Application No: LU/349/20/HH
Site Address: 32 & 33 Mariners Quay Littlehampton BN17 5DA
Description of works: Extension of rear balconies. This application affects the character & appearance of the Littlehampton (River Road) Conservation Area.

Thank you for your internet representation made on 6th February 2021 which has been recorded as an objection with the comments as follows:

Proposed Elevations

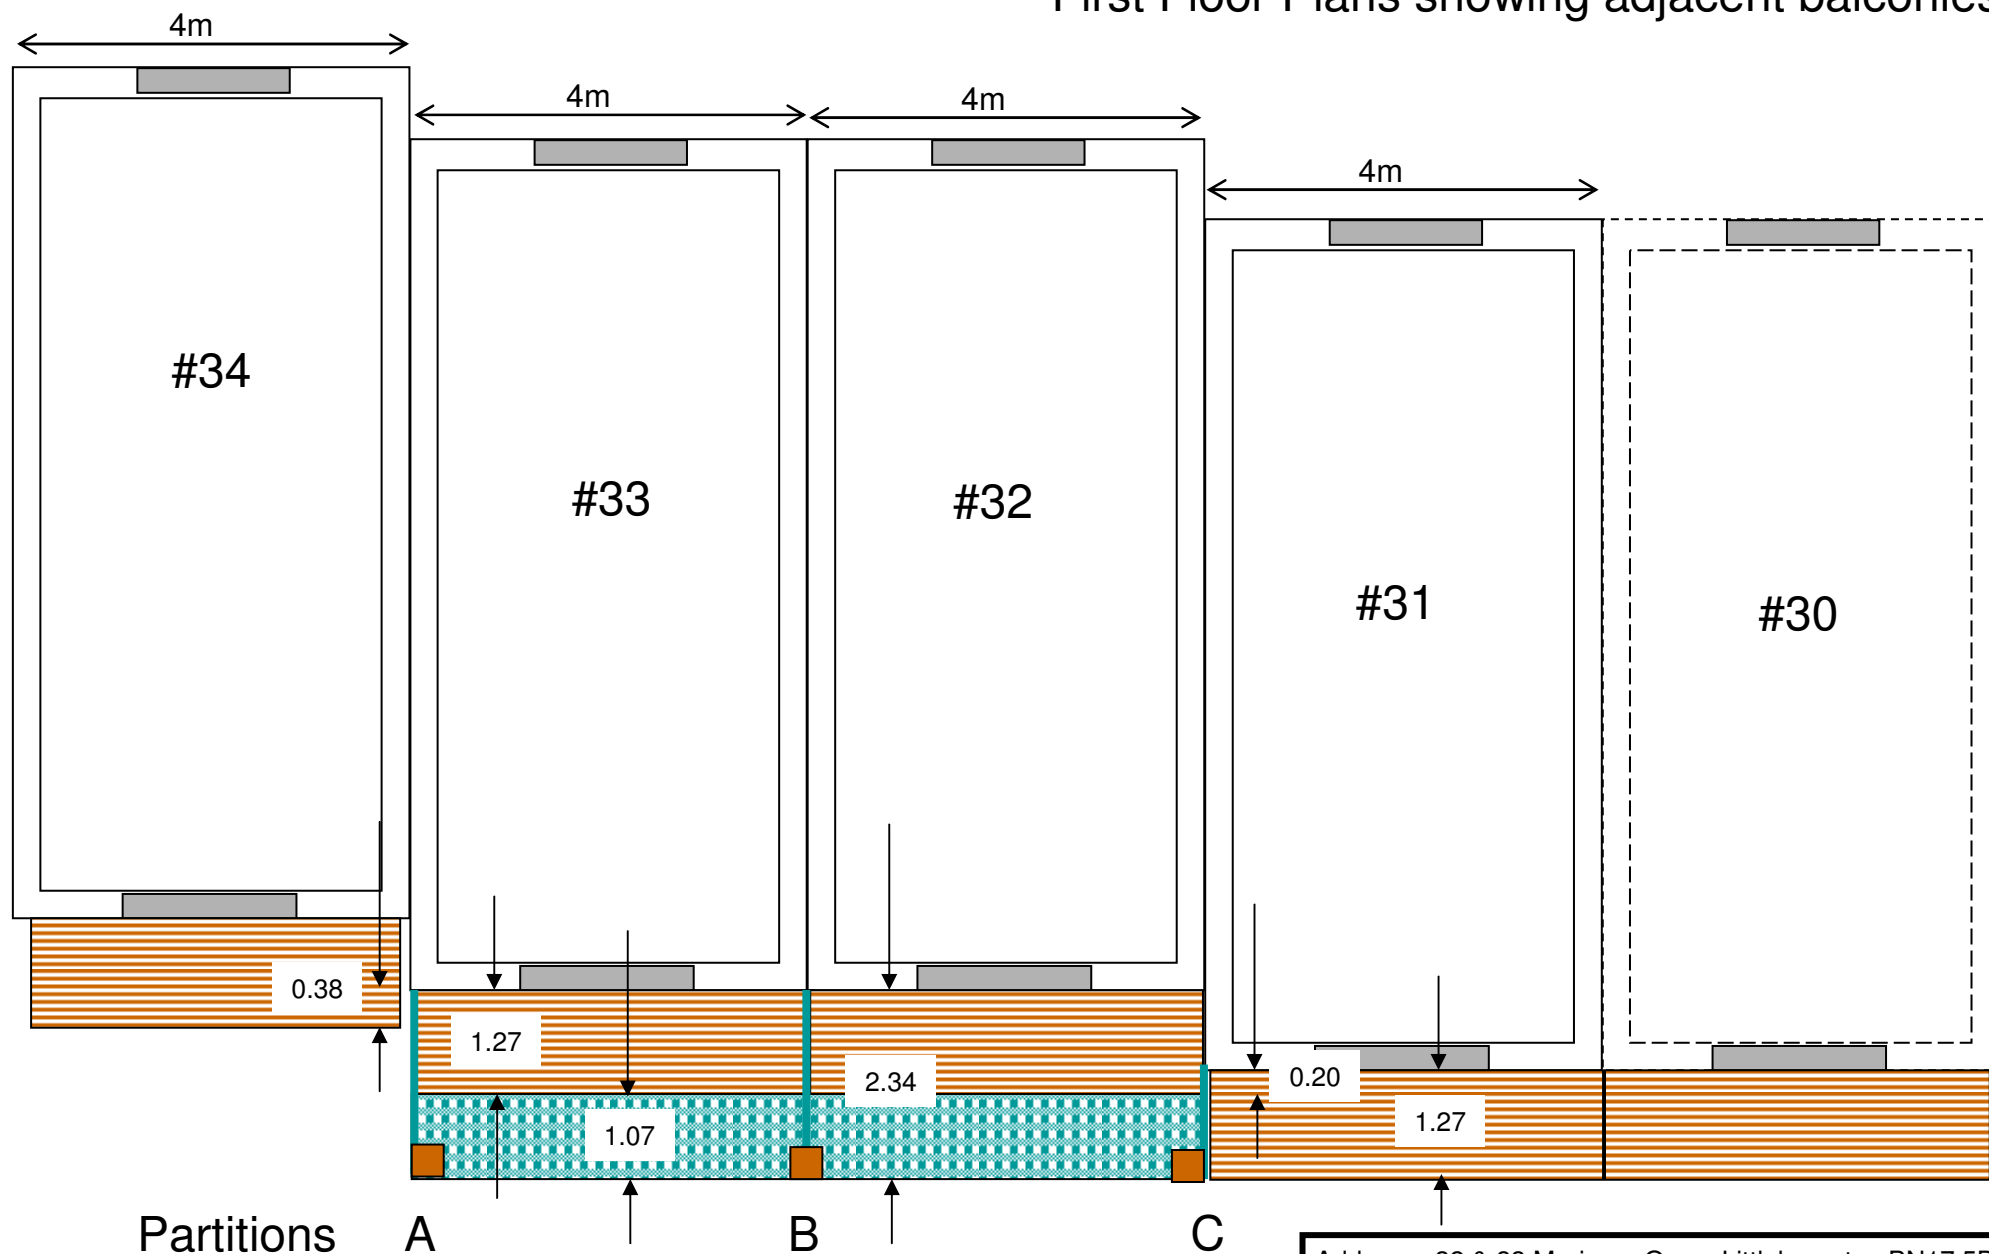
I visit this property many times a year and when I am there, I stay in the ground floor room. This room is shaded by the first floor balcony and its light is restricted by the balcony. If the adjacent balcony is extended, it will dramatically reduce the light available to that room. Secondly, the extension of the adjacent balcony will significantly reduce the privacy that can be enjoyed presently on the balcony of No31. As I understand it, when the houses were originally built, restrictions were placed upon these balconies, which are currently stepped, as to just how far they could extend and block light for the adjoining properties. Extending the balcony and erecting obscure glass screens will create an oppressive situation, while reducing the amount of light entering No 31. By enlarging the balcony of Nos32 & 33 it will enable larger gatherings to take place as well as barbecues and parties, increasing noise and also smells from the barbecue. From a security point of view these extensions will enable access to be readily gained via the new supports and posts, leaving No31 - and indeed Nos32&33 - open to illegal entry. One of the key aspects of these houses with their balconies as at present is that they were designed to afford residents great views both up and down river. These would be greatly restricted. Another point which should be considered is that the residents at No32 live in Surrey and only visit perhaps 6 times a year for just a couple of days whereas Mrs Devlin lives there all the time and so the negative effect will be much greater for her. Extending these two balconies will also destroy the present appearance of the block of houses, something that is not normally permitted in a Conservation Area, which applies to this whole block. One has to ask whether this application is the real reason for the extension? Could it be that the present owners see this as the first step in extending the downstairs room, which again would totally destroy the present uniform design and would create a precedent for other neighbours. I totally object to this application and ask that it be thrown out.
